Tween Bridge Solar Farm

8.21 Written Responses to ExQ2

Document Reference: 8.21

Deadline 4 21 July 2026

Figure 6.4 Landscape and Visual Mitigation Strategy

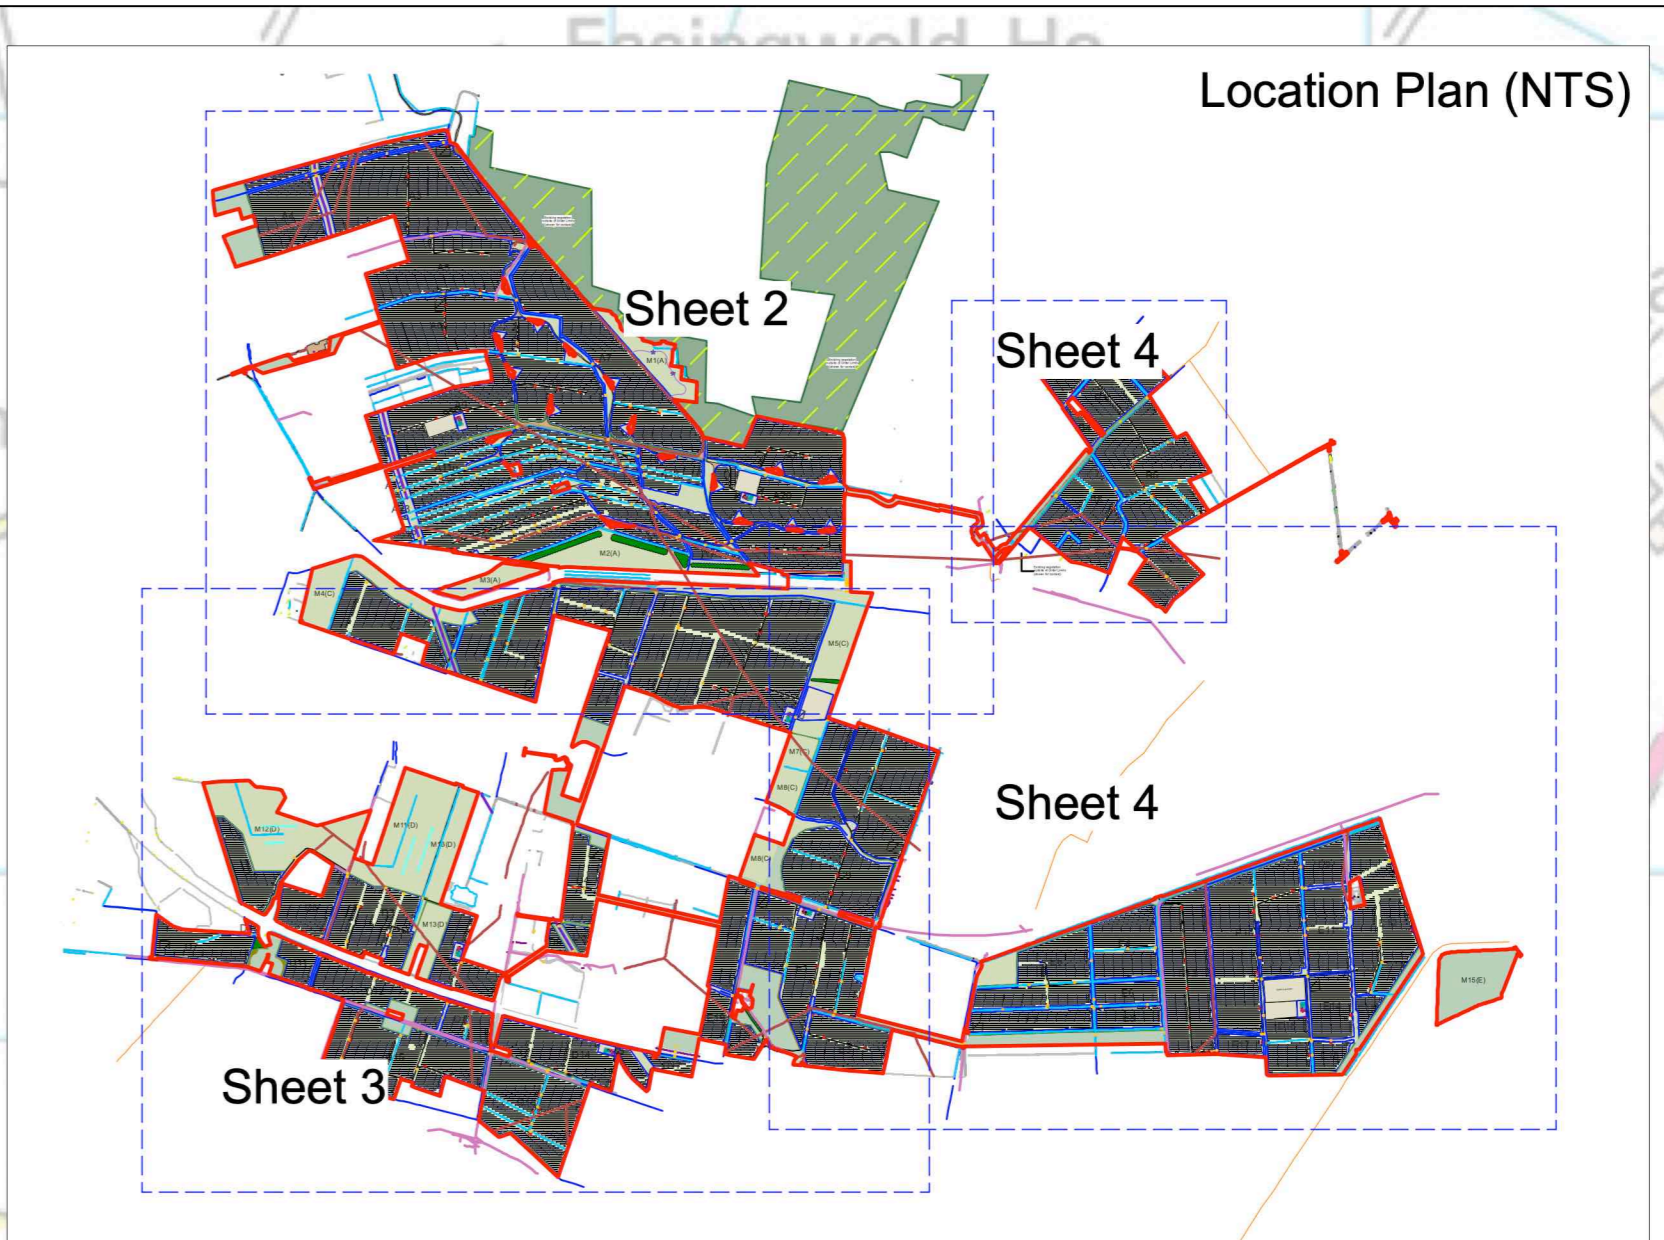
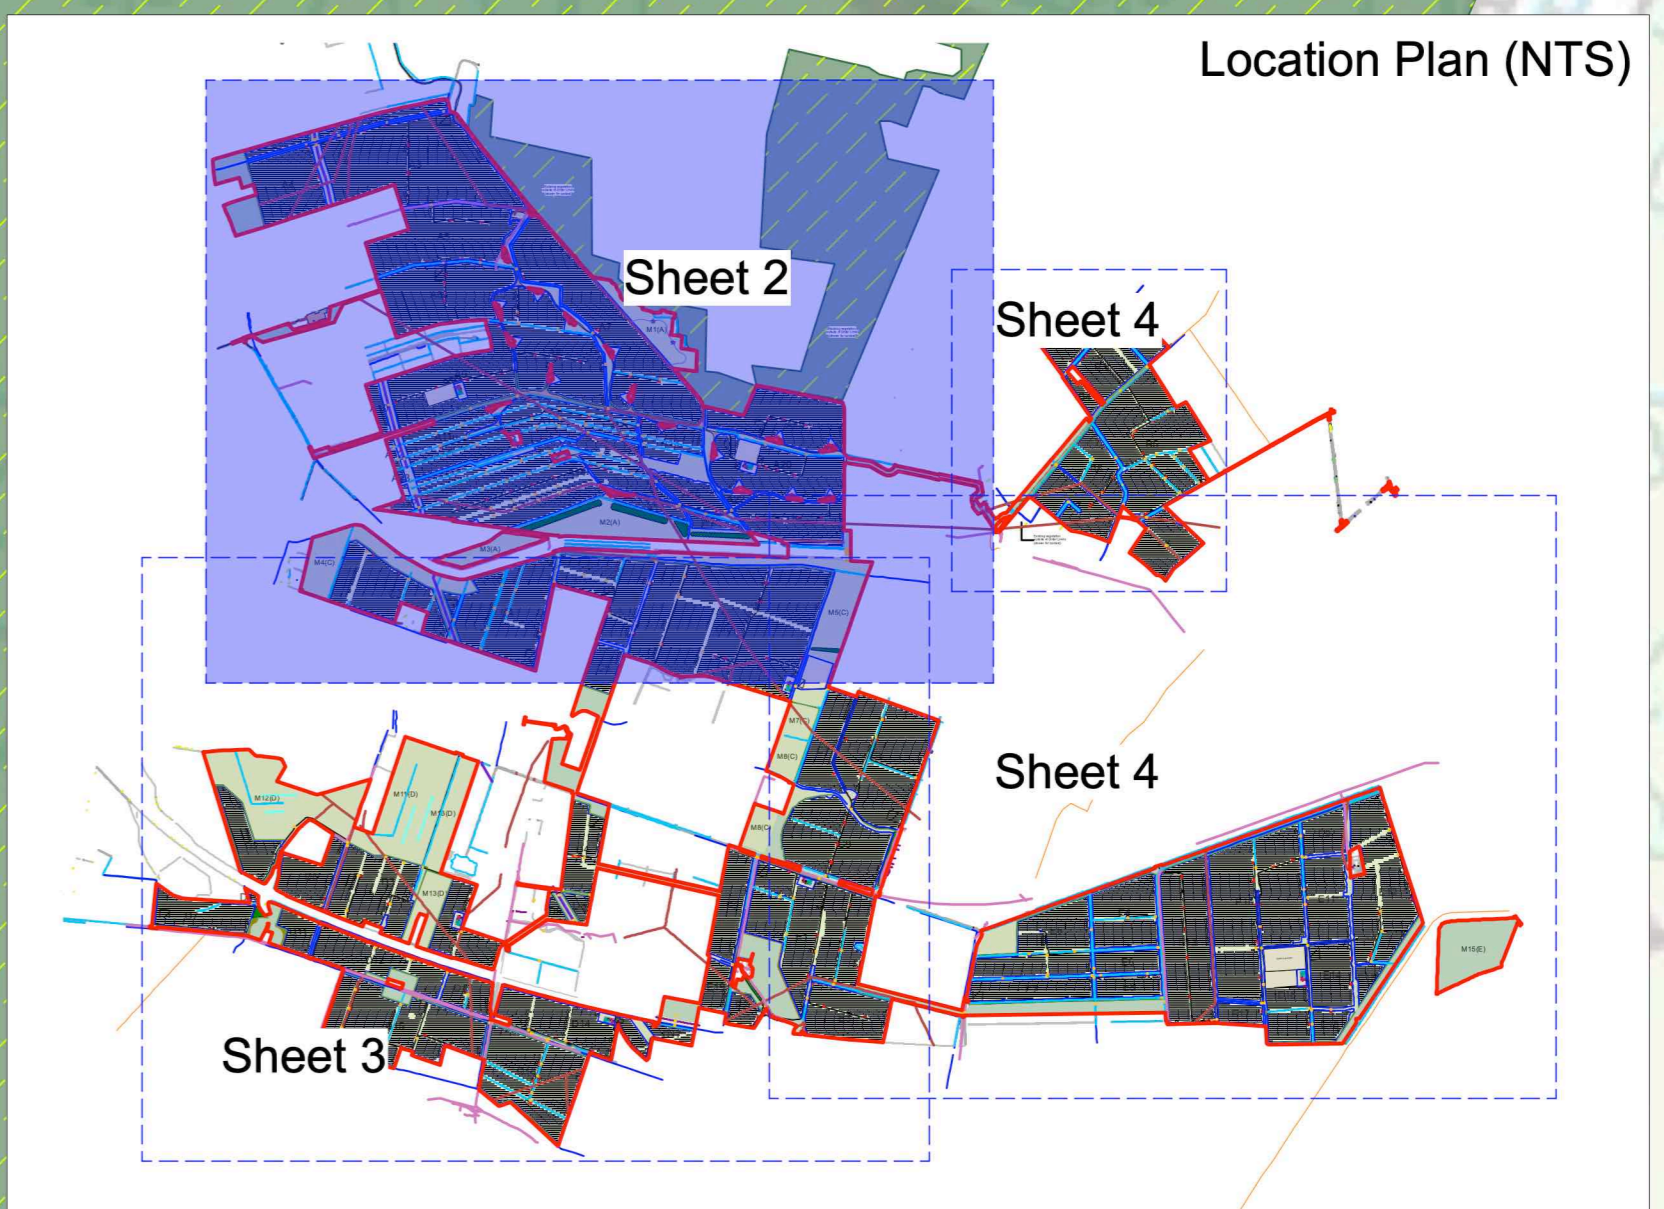
Q2.2.4	Applicant	Q2.0.21 Further to EXQ1 Q2.0.21 [PD-010], could the applicant please update ES Chapter 7 [REP2-035] paragraphs 7.5.192 to 7.5.197 to describe exactly which habitats are being created or enhanced? It is noted that descriptions are provided in relation to the construction phase (para 7.5.105) but not the operational phase effects (at paragraphs 7.5.192 to 7.5.197).	The Applicant confirms that Chapter 7: Ecology and Nature Conservation [Document Reference 6.2.7 Revision 4] has been updated for Deadline 4 to describe exactly which habitats are being created or enhanced during the operational phase. This is provided at paragraphs 7.5.197 to 7.5.198 and includes detail on: • modified grassland creation located underneath and around solar panels; • other neutral grassland created outside the security fencing, along buffers to retained hedgerows, ditches and woodland, and margins around mitigation parcels; • mixed native scrub creation across the Scheme, • new native hedgerow creation, including hedgerows with trees, across the Scheme, along with retained hedgerows to be enhanced;

• new tree planting across the Scheme as well as retained and enhanced existing mature and semi-mature trees; and • new native woodland across the Scheme and enhancement to retained woodland. All new and retained habitats can be seen within the Environmental Statement Figure 6.4 Landscape and Visual Mitigation Strategy [Document Reference 6.4.6.4 Revision 5].
Q2.2.5	City of Doncaster Council (CDC), North Lincolnshire Council (NLC) and the applicant	Biodiversity Net Gain (BNG) Monitoring CDC's LIR [REP1-062] paragraph 9.35 sets out its suggested requirements for monitoring of BNG. It suggests that a Habitat Management and Monitoring Plan (HMMP) should be produced and implemented with involvement from both CDC and NLC. It suggests that normally a section 106 agreement (s106) would secure this. In response [REP2-089], the applicant has stated: 'The Outline Landscape and Ecology Management Plan [Document Reference 7.6	The Applicant confirms that Outline Landscape and Ecology Management Plan [Document Reference 7.6 Revision 5] is secured by Requirement 8 of Schedule 2 to the draft DCO [Document Reference 3.1 Revision 7]. The Outline Landscape and Ecology Management Plan includes relevant implementation and monitoring requirements, particularly in Table 4-1 and sections 6 and 7. The final Landscape and Ecology Management Plan must be
